20th June 2022

OBJECTION TO AMENDMENTS RELATING TO PLANNING APPLICATION FOR DEMOLITION OF EXISTING STABLE BLOCK AND ERECTION OF DETACHED DWELLING FORMING ANNEXE ACCOMMODATION ASSOCIATED WITH LEATHER HALL BARN, BRADSHAW ROAD, HONLEY, HOLMFIRTH, HD9 6RJ, AND CHANGE OF USE OF LAND TO DOMESTIC GARDEN.

LPA REF: 2021/94531

Client E. DALTON	
Project Leather Hall Barn, Honley.	
Drawing Proposed redevelopment of existing stable to form granny flat ; Location Plan Planning Application	
Number 4378-00-01c	Checked Scale @ A3 As Marked
Date 02/2021

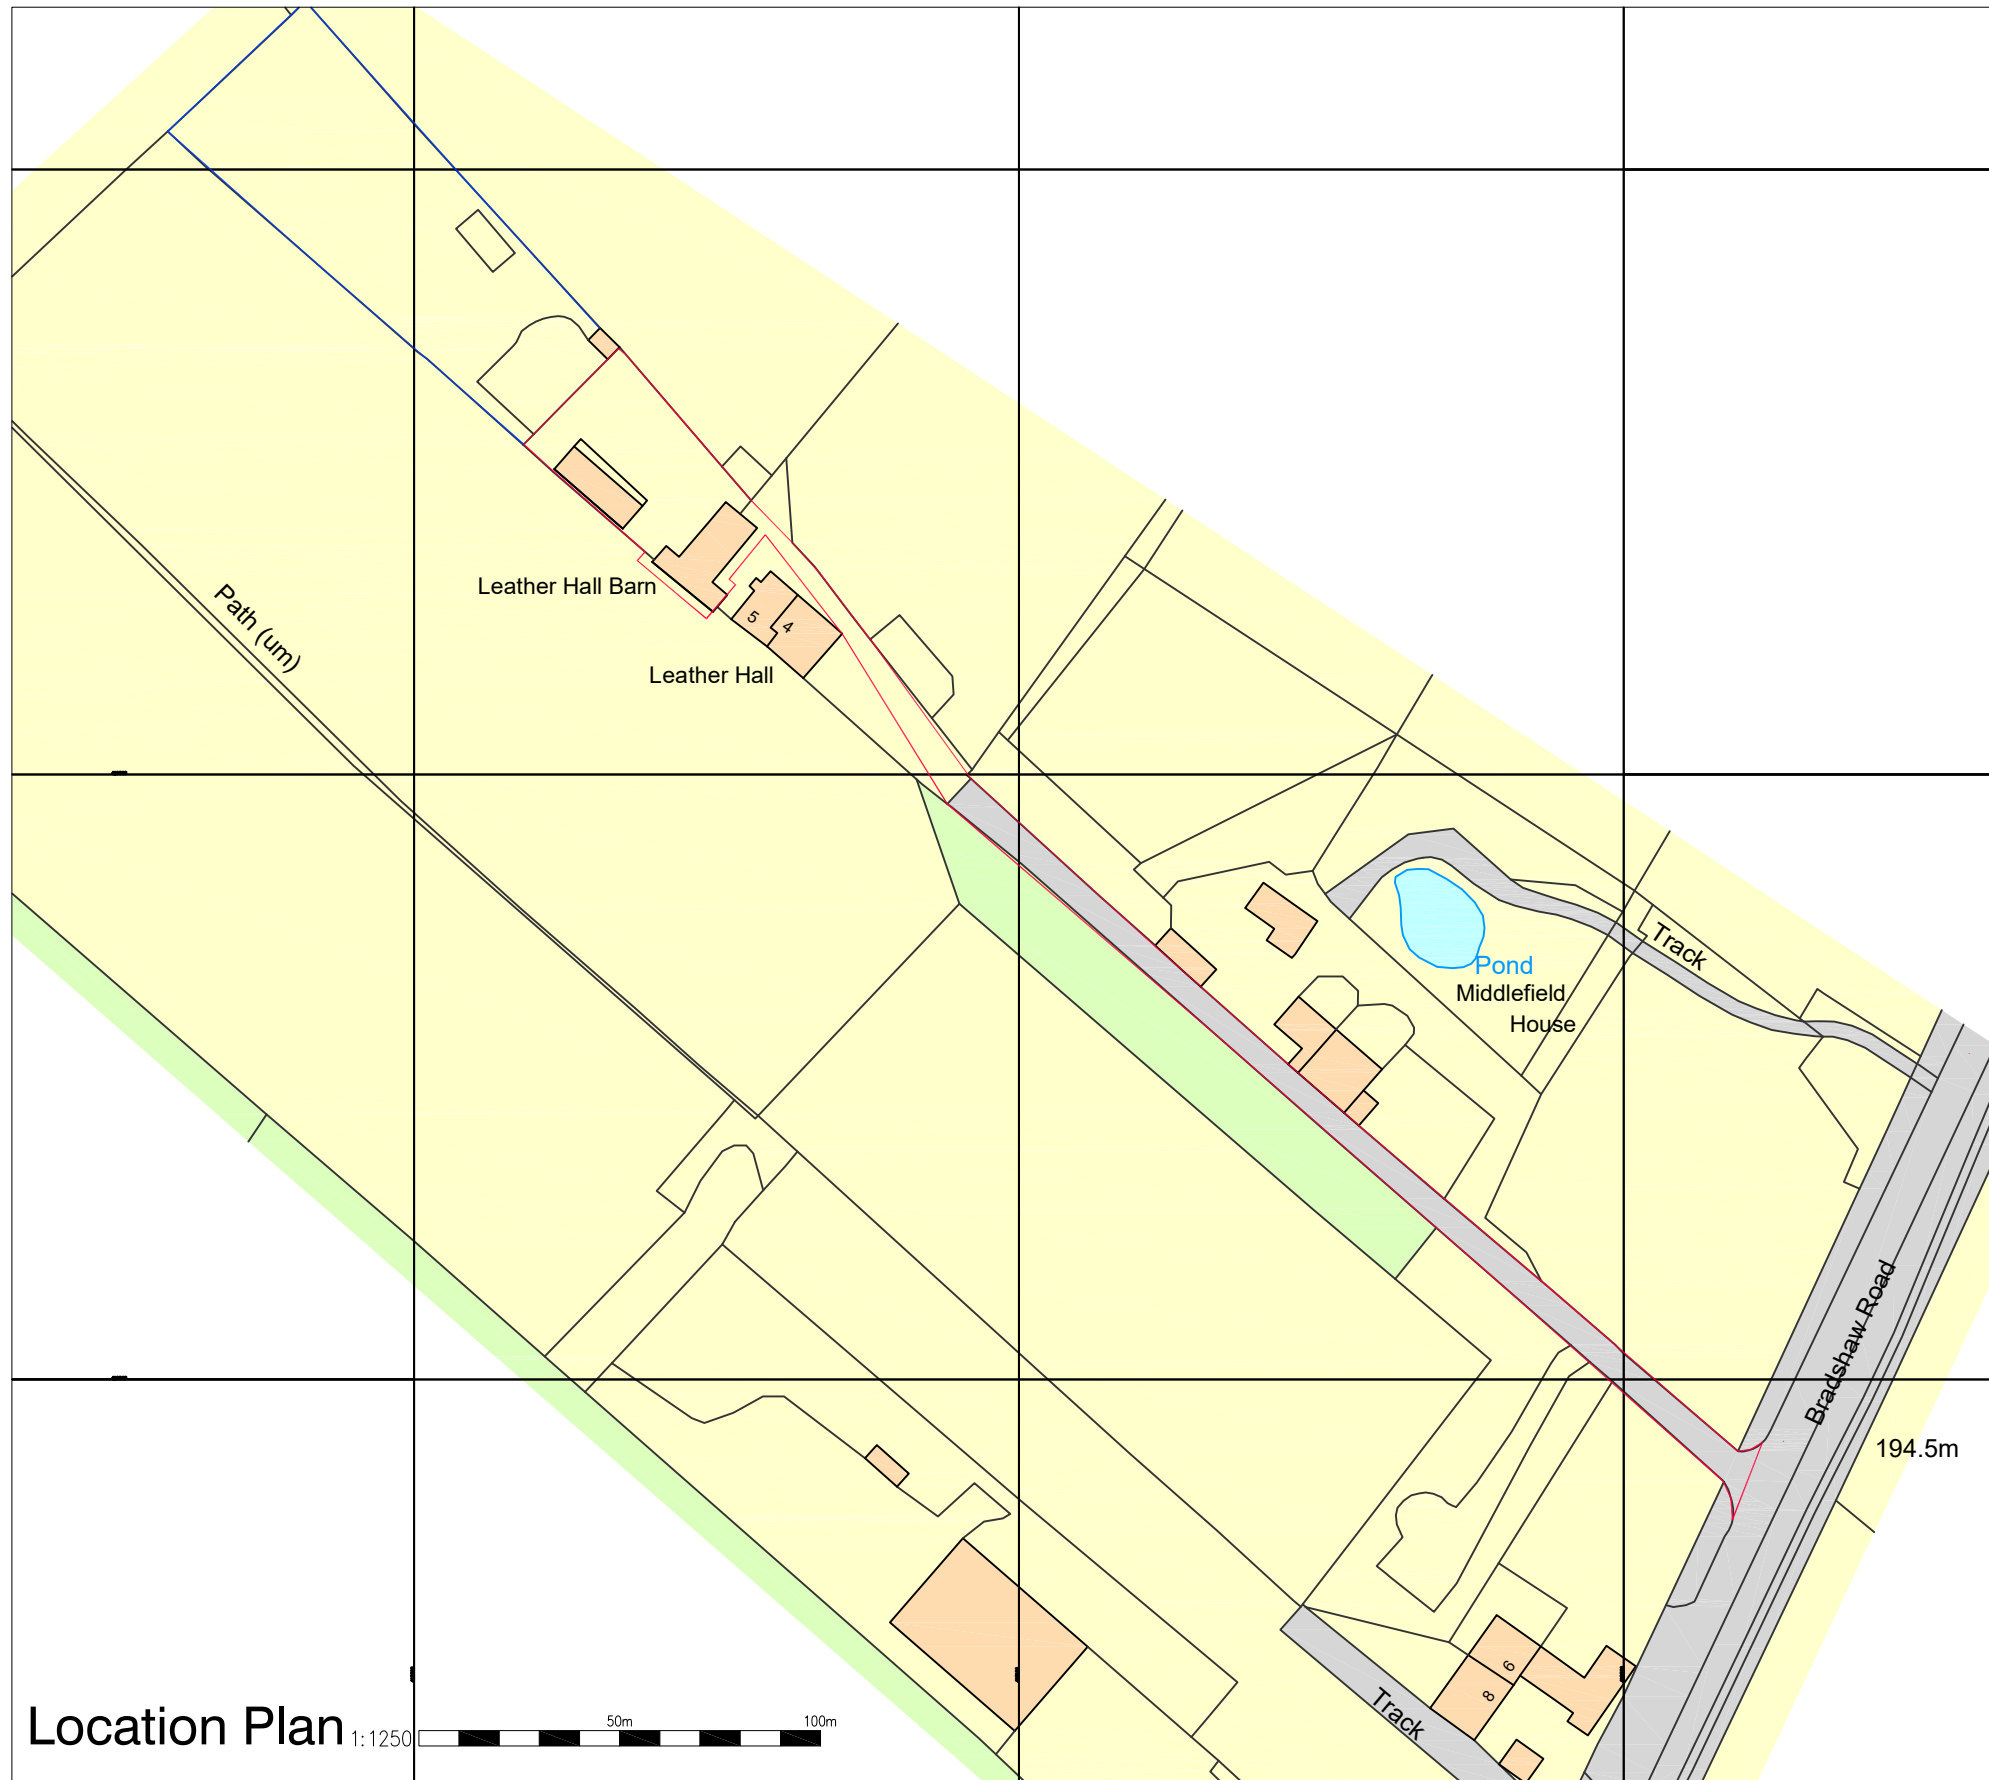
It is also noted that the description of the proposed development has been amended and now includes 'change of use of land to domestic garden.' The fact still remains however, that the extension of gardens within the Green Belt are likely to have a detrimental impact and cause harm to openness. This is presumably why, in accordance with Policy LP58 in the Local Plan, proposals to change the use of land in the Green Belt to domestic gardens will not normally be permitted unless very special circumstances exist. Our client is still of the opinion that very special circumstances have not been demonstrated in this case and therefore the proposed extension to the garden is also inappropriate development in the Green Belt.

As mentioned in our previous letter, the applicant also owns the land directly north-west of the application site, edged in blue on the Location Plan. If approval is given for an extension to the original domestic curtilage, what is stopping the applicant from encroaching into this area of land in the future causing even further harm to openness? As mentioned previously, an area of hardstanding has already been constructed on this land without planning permission.

Proposed Site Plan & Section

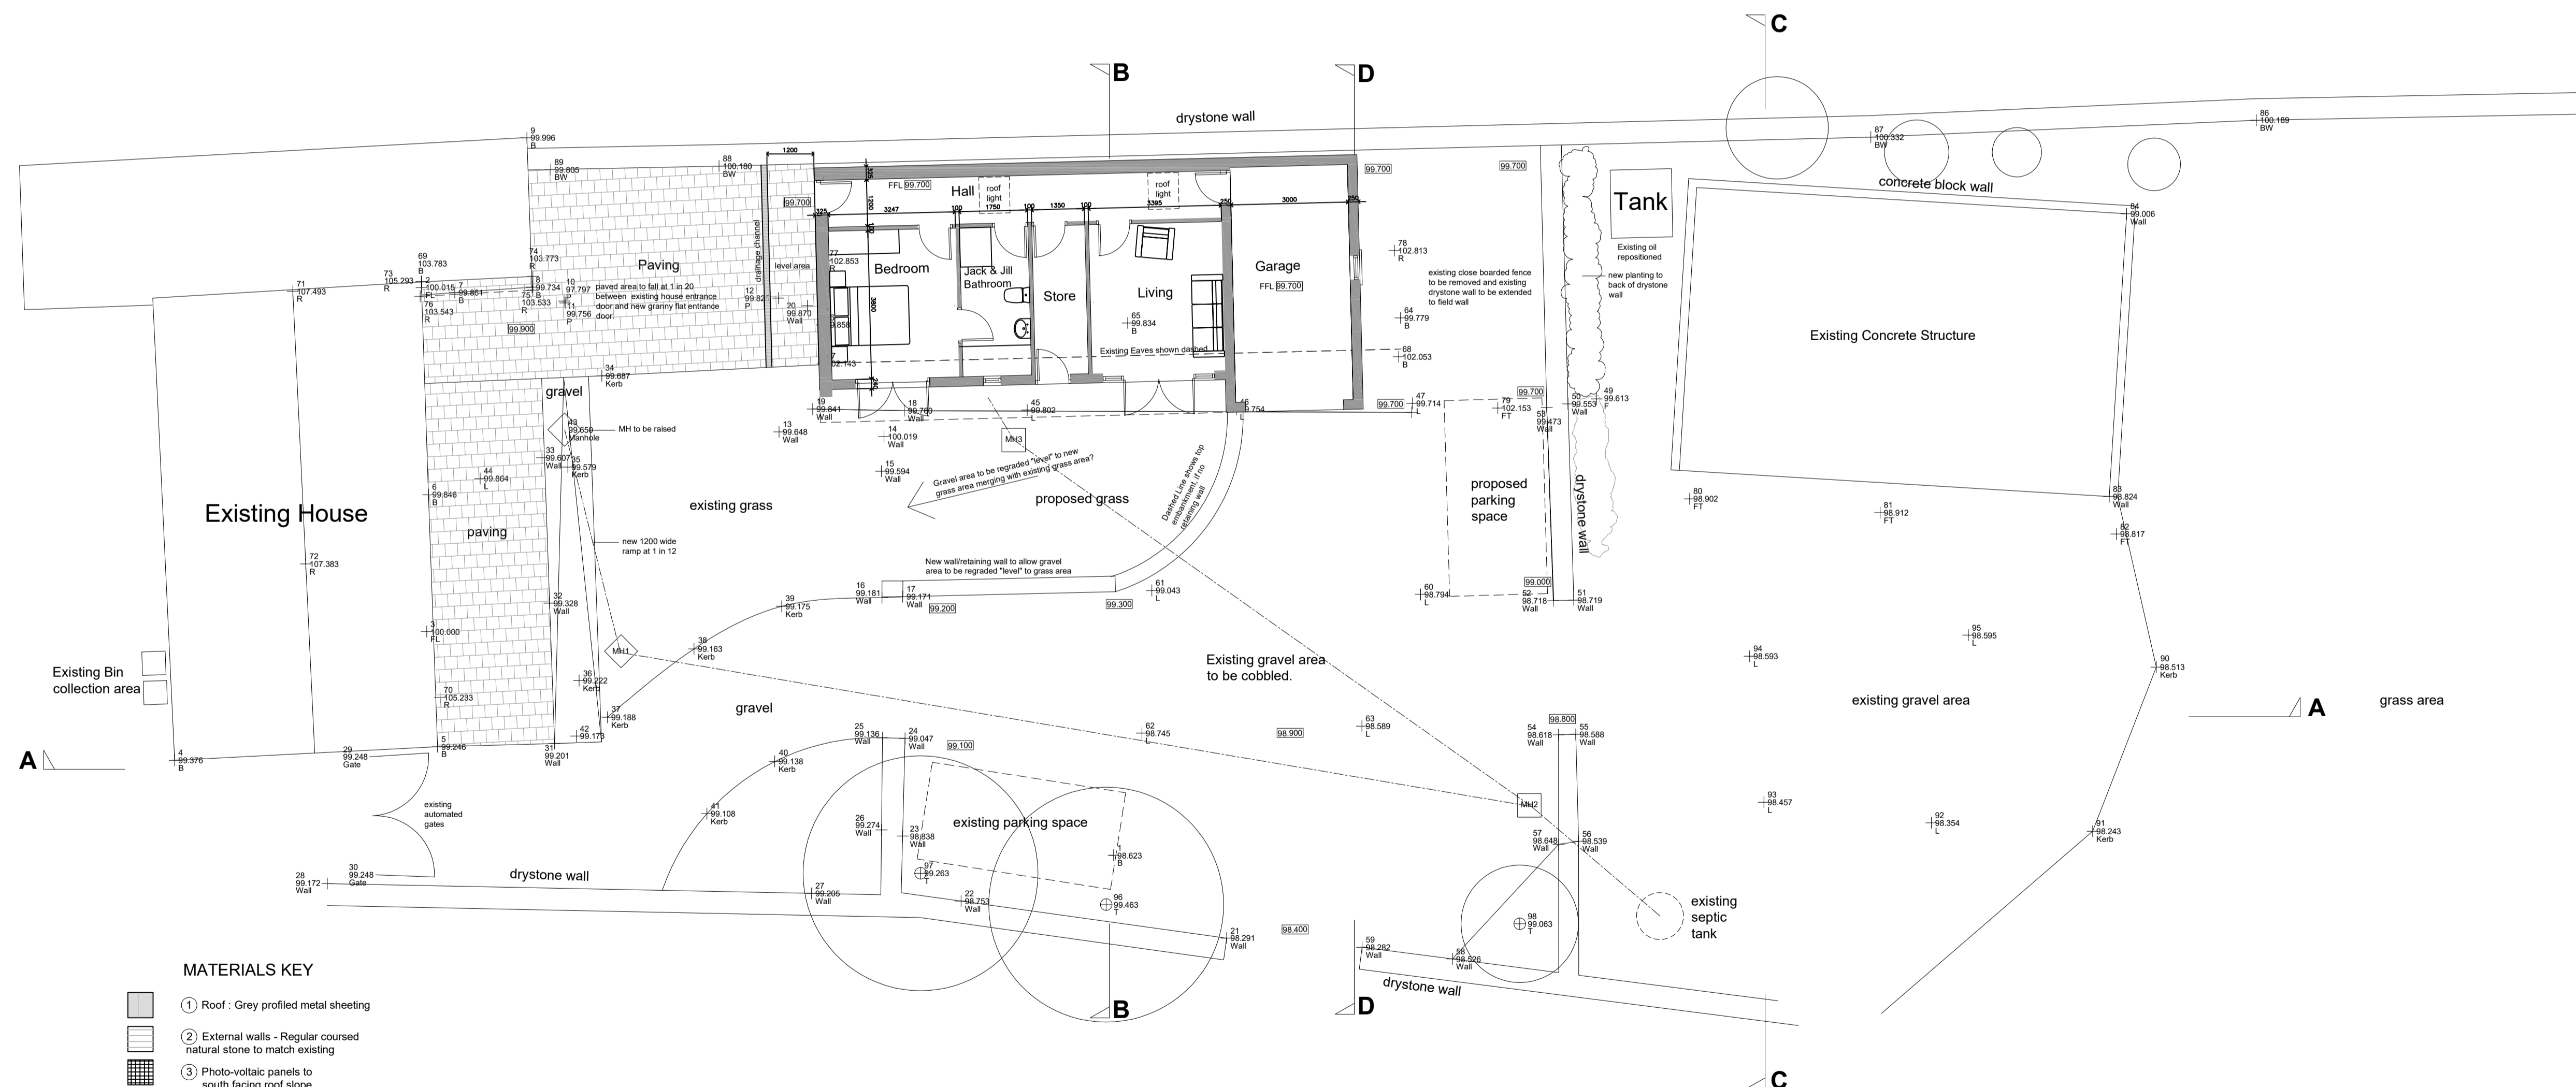
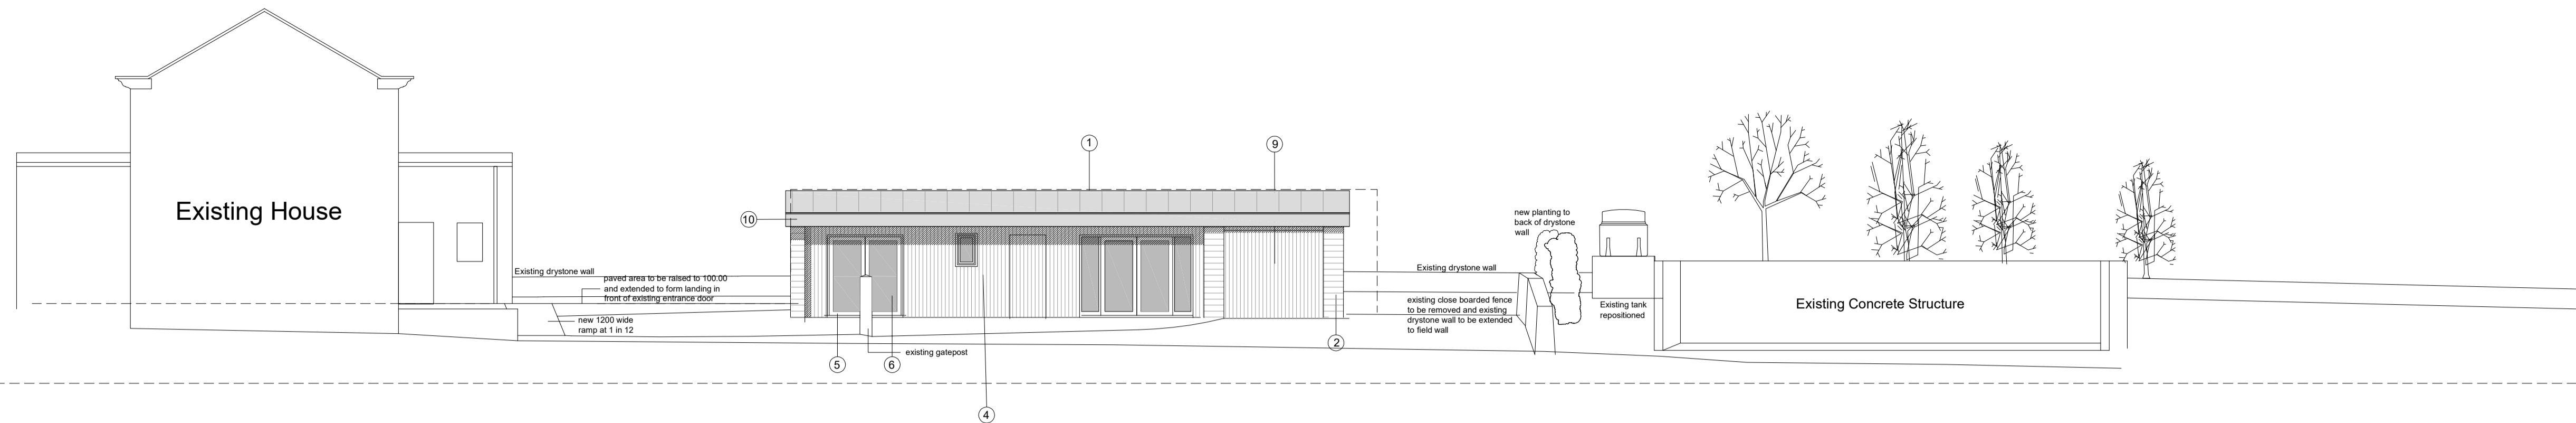
It is noted from the amendments that the scale of the proposed dwelling/annexe has been reduced in size to more closely reflect the size of the existing stable. However, it is not only the size of a building that determines its overall impact on the openness of the Green Belt. As was mentioned in our previous letter, the proposed use of the building for residential would be more intensive than its existing use as stables. The domesticated design of the dwelling/annexe including the proposed materials and solar panels, and the additional paraphernalia that is likely to be associated with its use, such as garden furniture, hardstanding areas, bins etc, would be of detriment to the openness of the Green Belt.

Although the size of the proposed dwelling/annexe has been reduced, the internal layout remains unchanged. The inclusion of a 'store' with an internal and external door is therefore still concerning as this could easily be converted into a kitchen. As was mentioned previously, if the store is genuinely proposed to be a store, why is there a need for an internal door? Likewise, why is there a need for an internal garage door if this is proposed to be used by the applicant and not for the use of grandparents staying in the annex? ¹
